From: Sarah Burrow <Sarah.Burrow@arun.gov.uk>
Sent: 11 August 2021 10:51
To: Planning.Responses <Planning.Responses@arun.gov.uk>
Cc: Simon Davis <Simon.Davis@arun.gov.uk>
Subject: RE: Planning Consultation on: WA/58/21/PL

Engineers Comments Regarding Surface Water Drainage

Application No: WA/58/21/PL
Registered: 6th July 2021
Site Address: Brookview Nursery Eastergate Lane Walberton BN18 0BA
Grid Reference: 496009 106070
Description of Works: The removal of outdoor storage, including caravan & polytunnels, the erection of 7 workshop units comprising of 12 offices & 3 commercial units, associated parking, drainage and turning spaces. This application is in CIL Zone 3 (Zero Rated) as other development

Drawing Status	PLANNING		
Client	Philip Sowden		
Project	Land at Brookview Nursery Eastergate Lane, Walberton BN18 0BA		
Drawing Title	Impermeable Areas & Catchment Appraisal		
Scale	Date	Drawn By	Checked By
1:250	07/06/21	DJL	MJA
Drawing No.	D1963-PL200		Rev.
		-

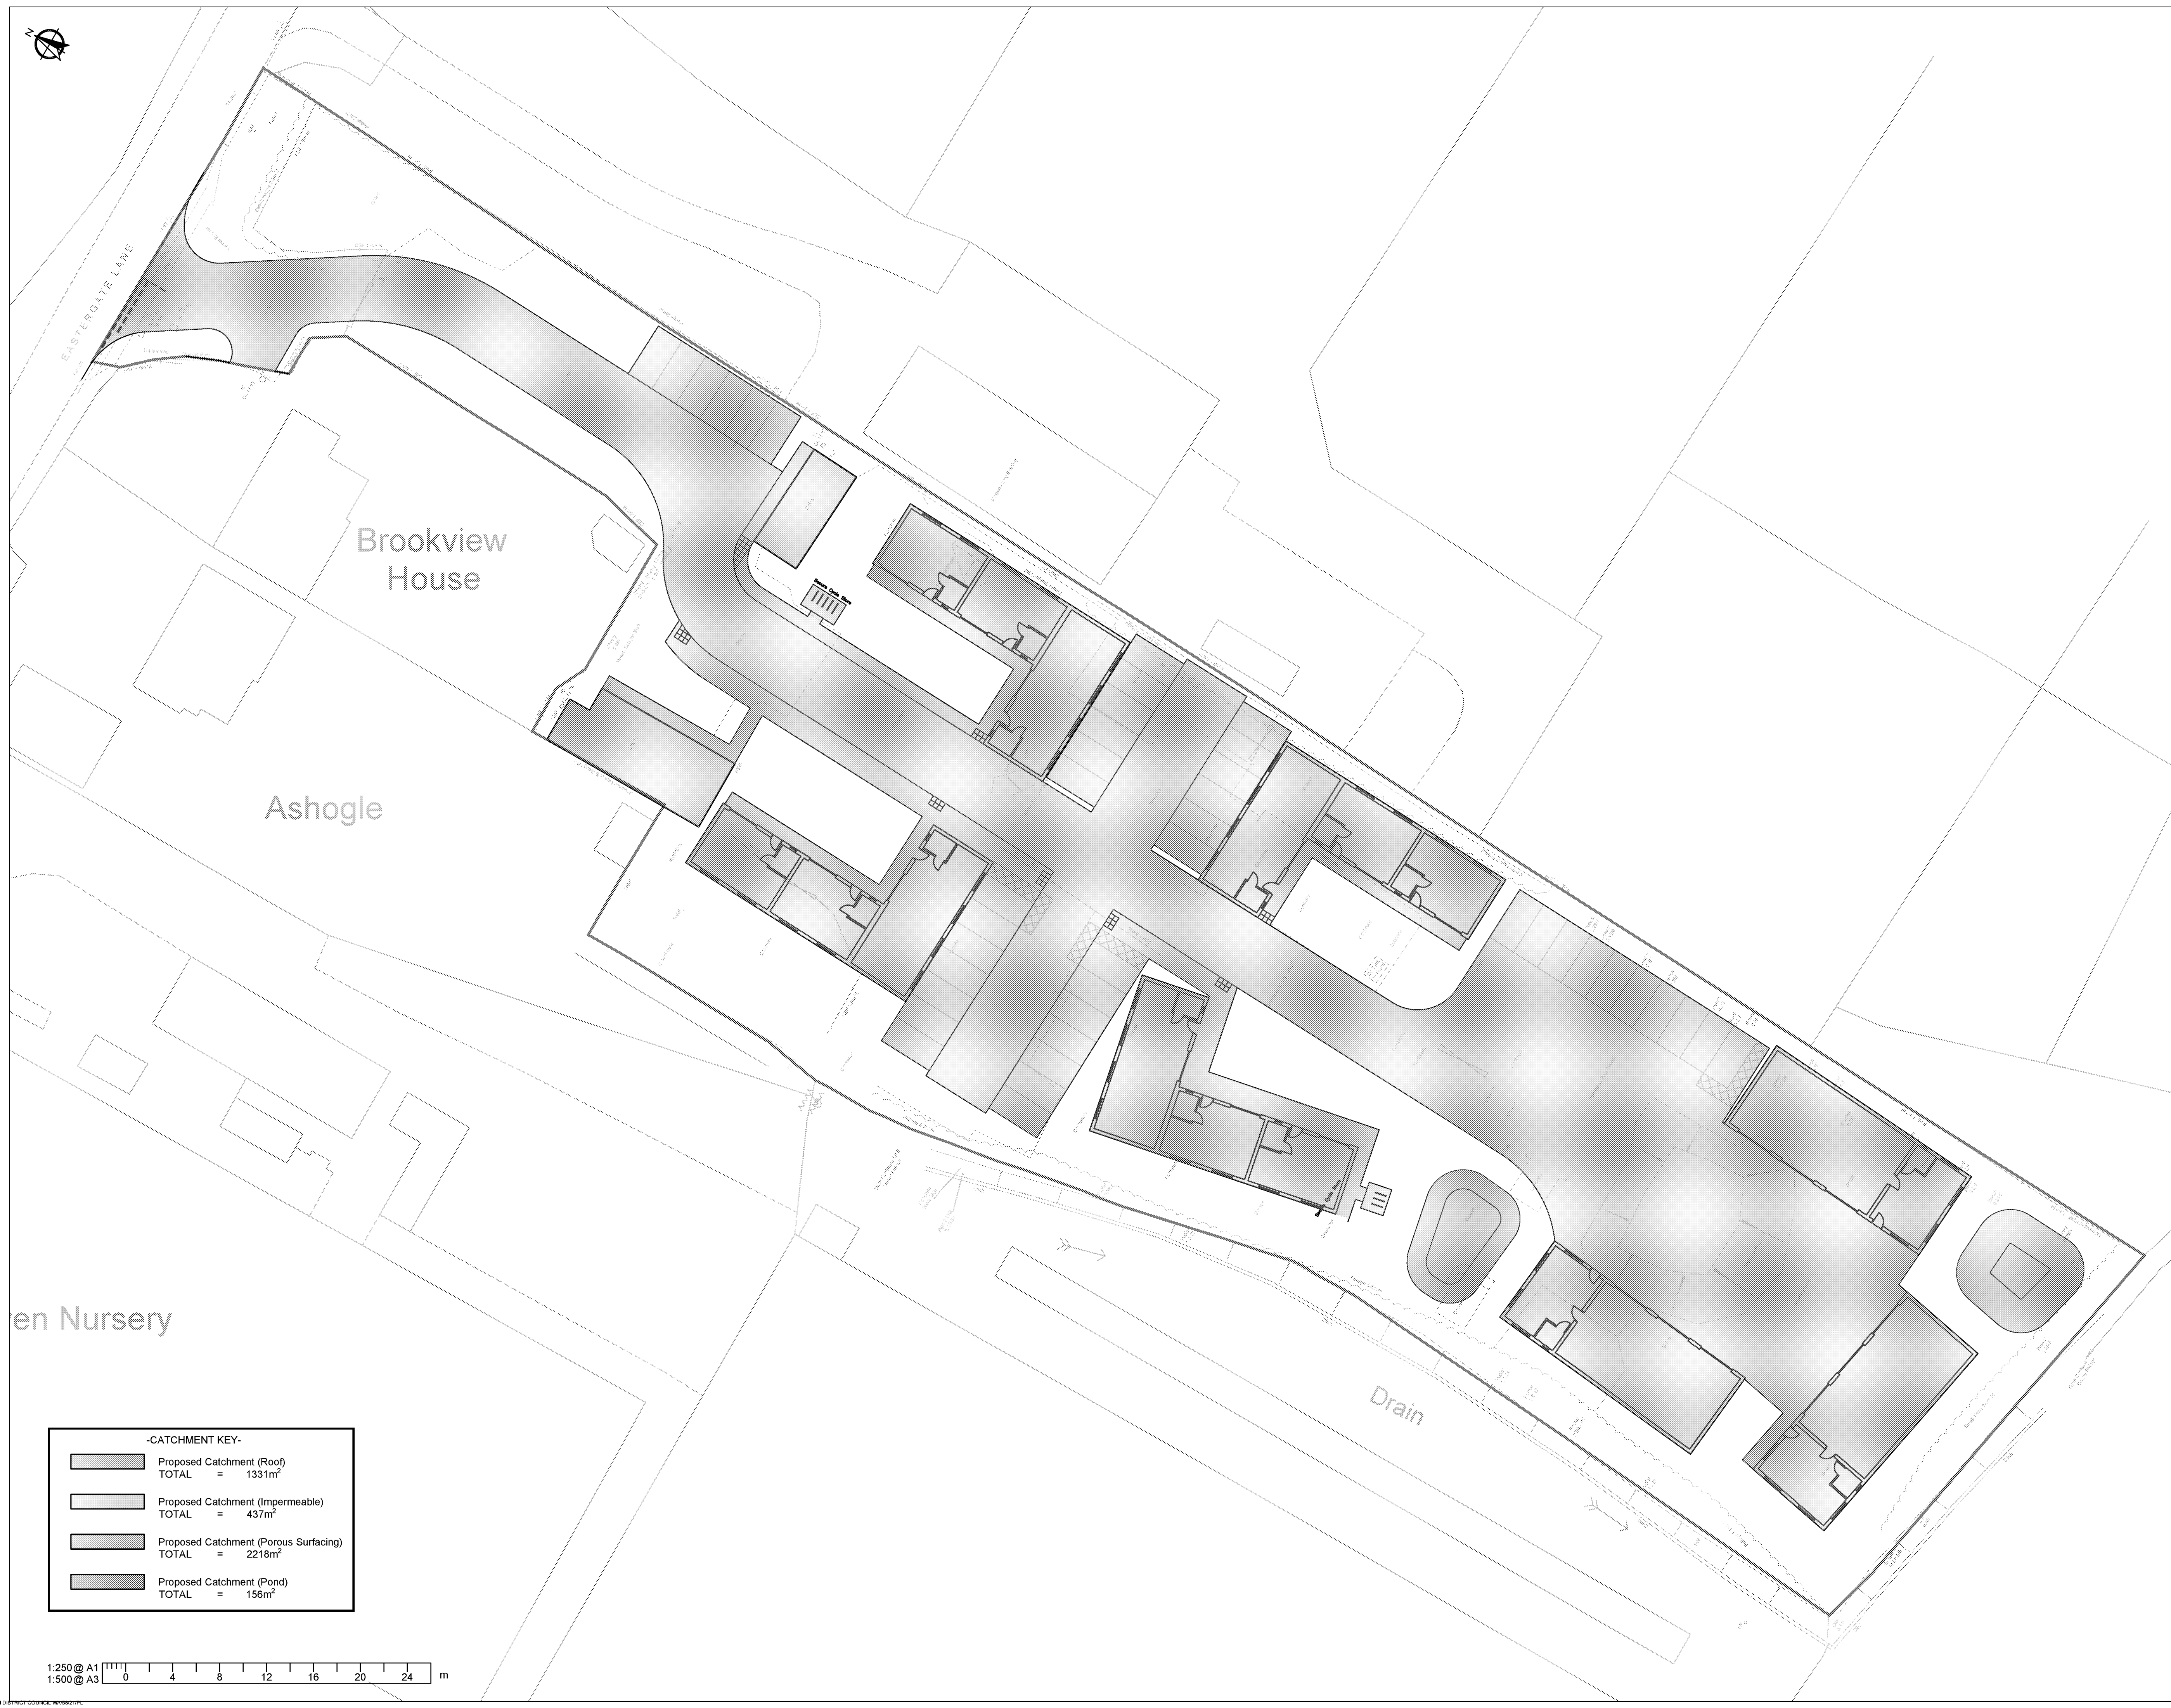
On the basis of an assumption that infiltration will not be viable on the site (due to the expected clay soils and knowledge of the existing surface water drainage system) the applicant is proposing to collect surface water from the roads (via permeable paving) and roofs in two ponds (at the west and south of the site) before discharging it at a restricted rate to the watercourse which runs along the east and west boundaries. **IF** infiltration is found to not be viable following appropriate site investigations then we would support this strategy.

The applicant's engineers are encouraged to contact us and agree the level of winter groundwater monitoring and infiltration testing that is required for the site. If the proposed strategy is taken to detailed design stage then we would expect to see the discharge rates restricted to the greenfield 1 in 1 year runoff rate during all events up to and including the 1 in 100 year rainfall event with climate change. An alternative approach would be for discharge rates to be limited to a range of greenfield rates, based on the 1 in 1, 1 in 30 and 1 in 100 year storm events. **The current combined proposed discharge rates of 2l/s and 5l/s are likely to exceed this requirement.**

Proposed Block Plan
Scale 1:500

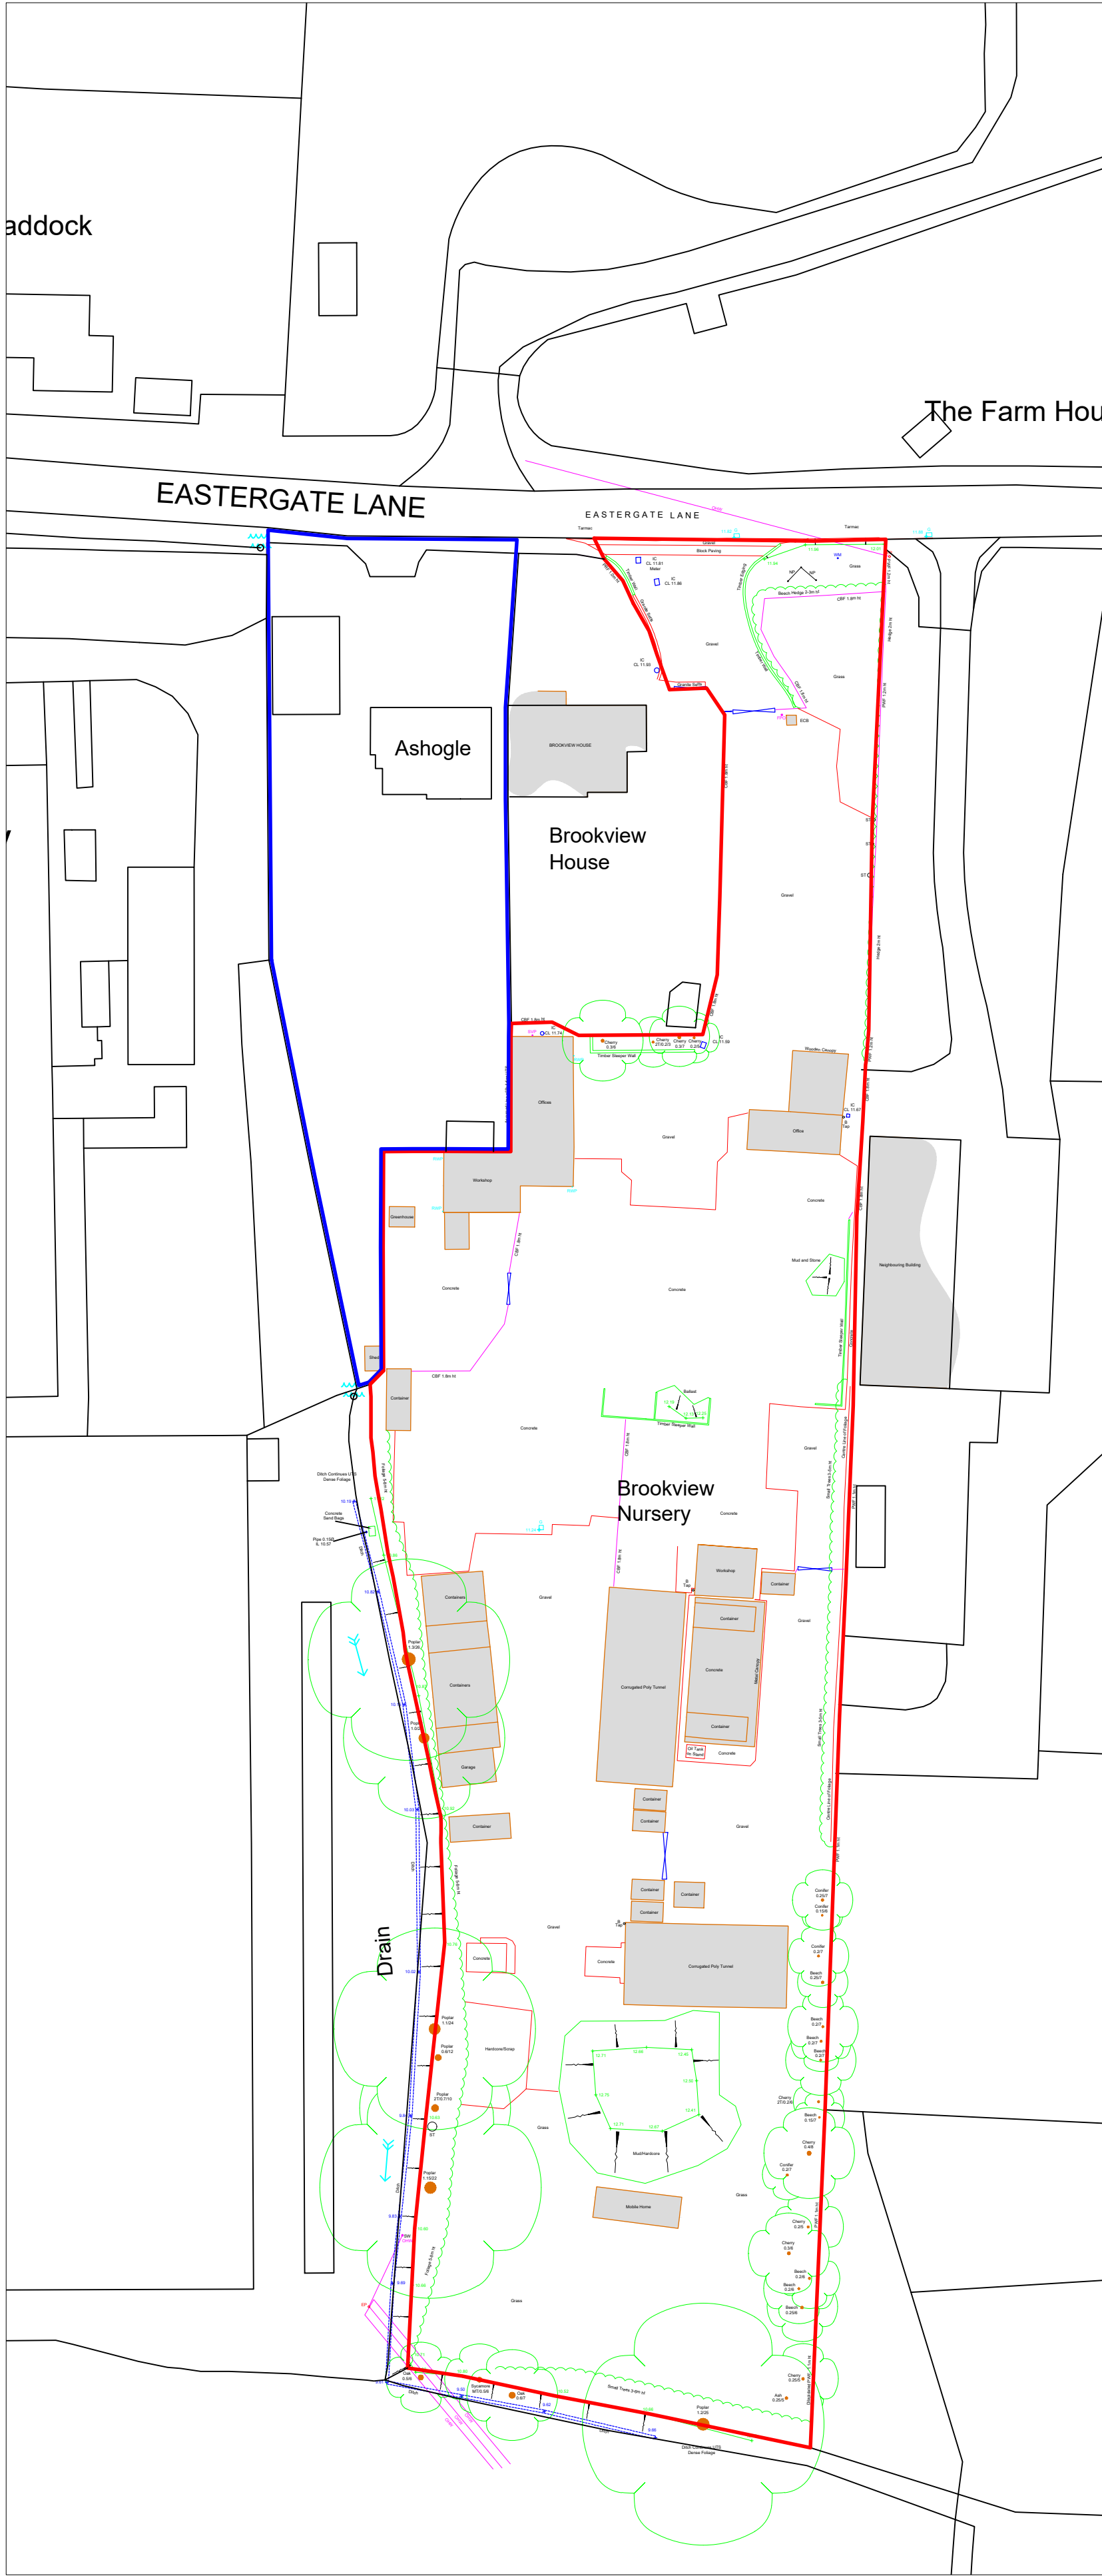
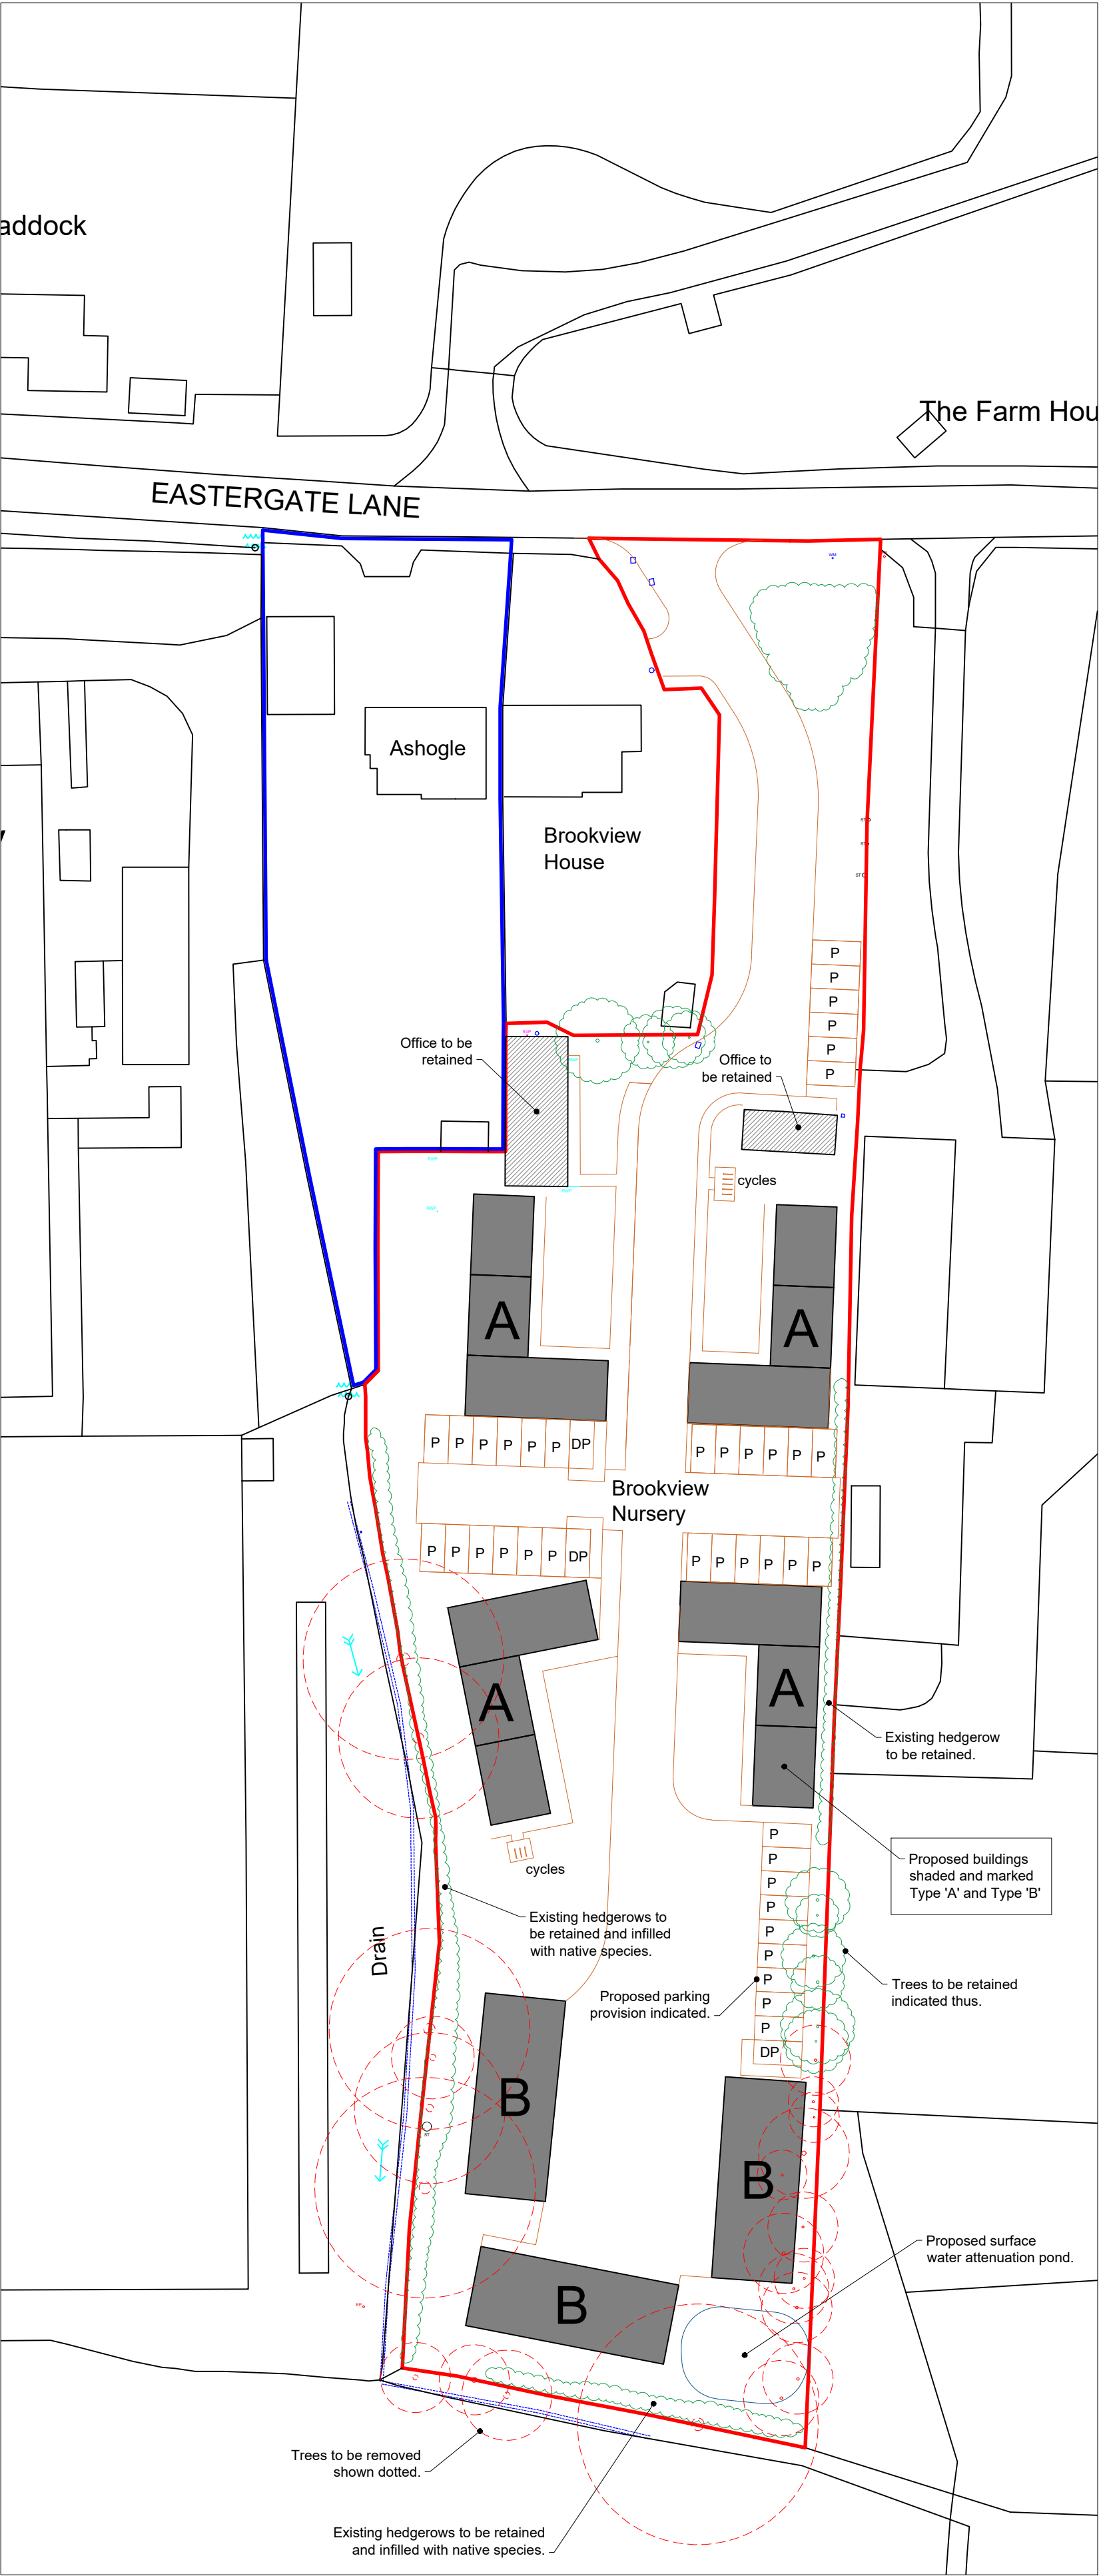
All buildings, structures and fences are to be kept a minimum of 3m from the watercourse to ensure access for maintenance.
